TAMIL NADU HOUSING BOARD
SPECIAL PROJECT DIVISION-I

Sub: TNHB -Special Project Division I - Proposed Construction of 510 No's of Multi Storied Building LIG flats (Stilt + 15 Floors) in S.No's.738part, 739part, 742 and 743part at MKB Nagar, Perambur Village, Perambur Taluk, Chennai -(150 LIG Block-I & 3 no's of 120 LIG Block 2,3 &4))under Self Finance scheme - Planning Permission-Remittance of DC and other charges paid receipt Requested -- Regarding.

Letter No.C3(N)/2530/2016,dated : ~~12~~ 12.2016

Sub: CMDA – Area Plans Unit – MSB (North) Division – Planning permission for the proposed construction of Multi storied building consisting of Block 1, Block 2, Block 3 & Block 4 of Stilt Floor + 15 Floors residential building with 510 dwelling units in S.No.738pt, 739pt, 742pt&743pt Perambur Village, Permbur-Purasawalkkam Taluk, Chennai— Remittance of DC and Other Charges – ~~DC~~ Advise sent – Reg.

TERRACE FLOOR PLAN BLOCK-1

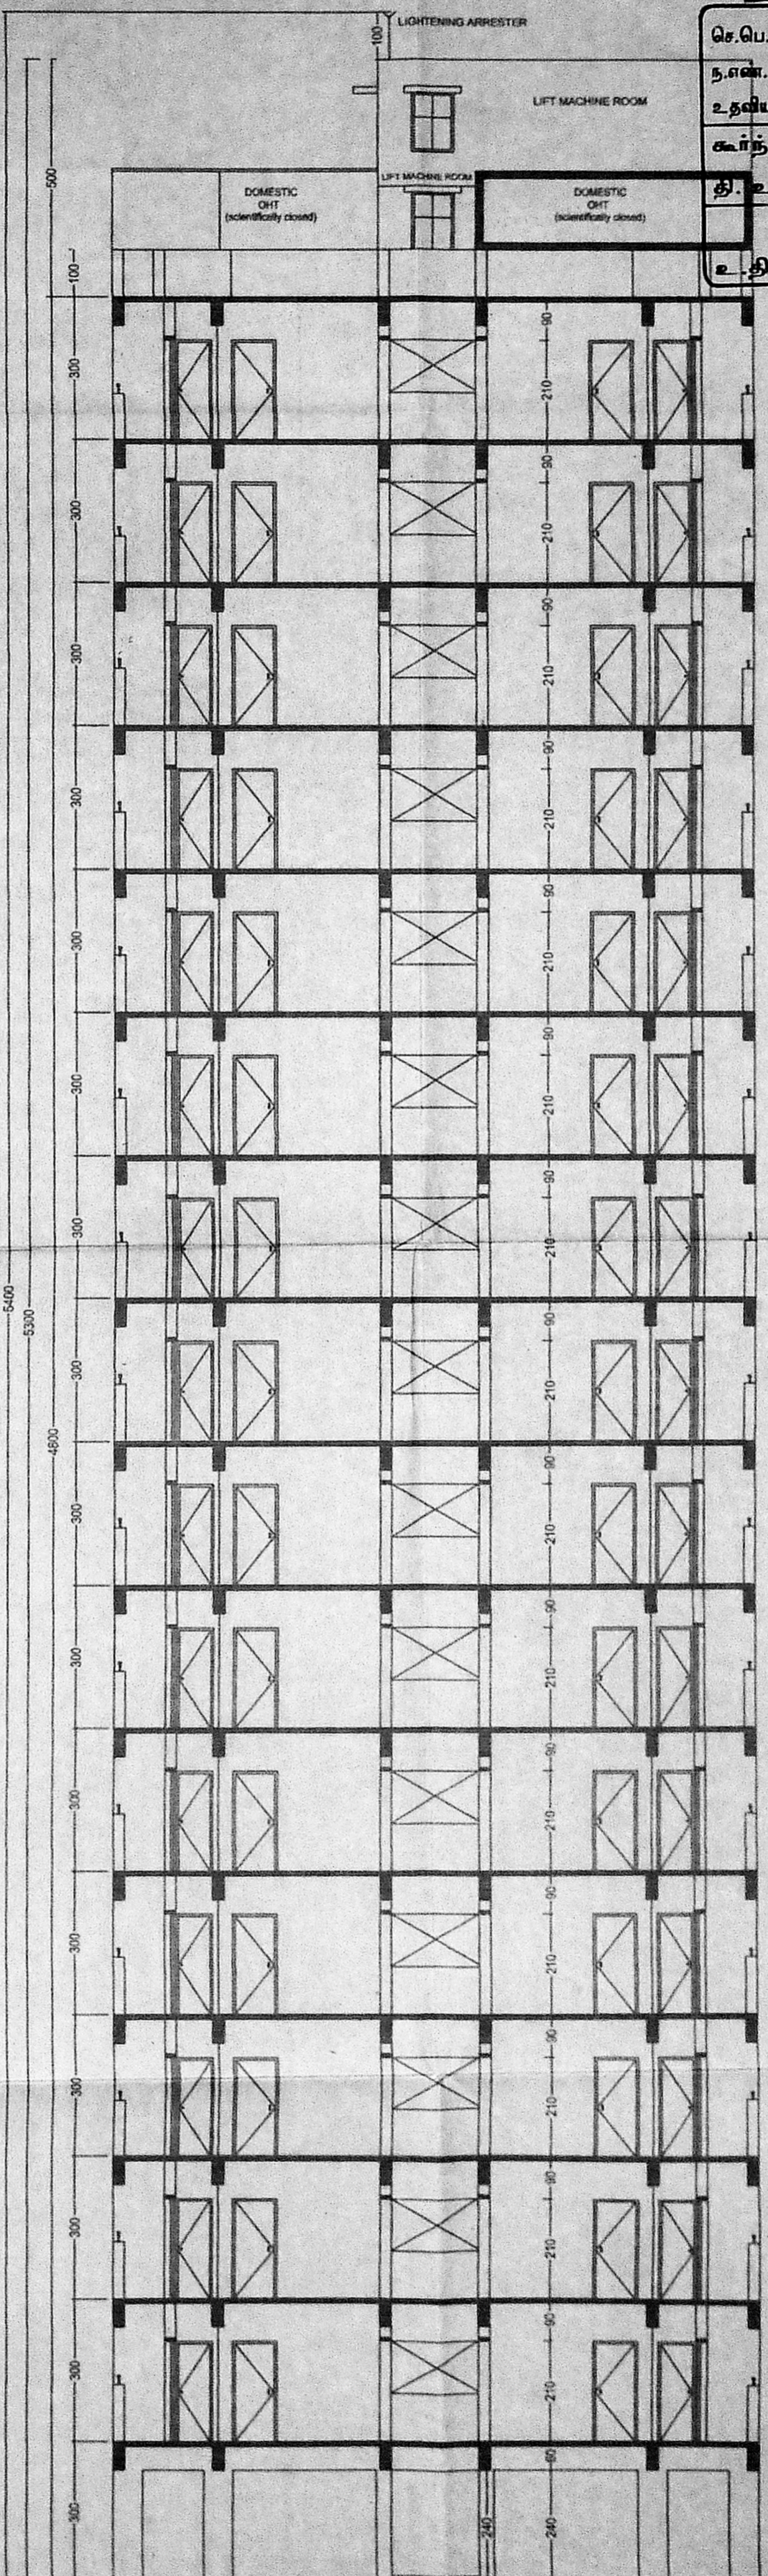
- 17) Site plan showing 10.0^m setback free from any hinderance as specified in the DF&RS NOC to be furnished.
- 18) Head room to be mentioned properly in the terrace floor plan.

- 19) NOCs from Traffic Police not received, NOC from IAF & AAI to be furnished.
- 20) 1/3rd area of terrace floor to be reserved for solar photo voltaic cells system to be shown in the plan.
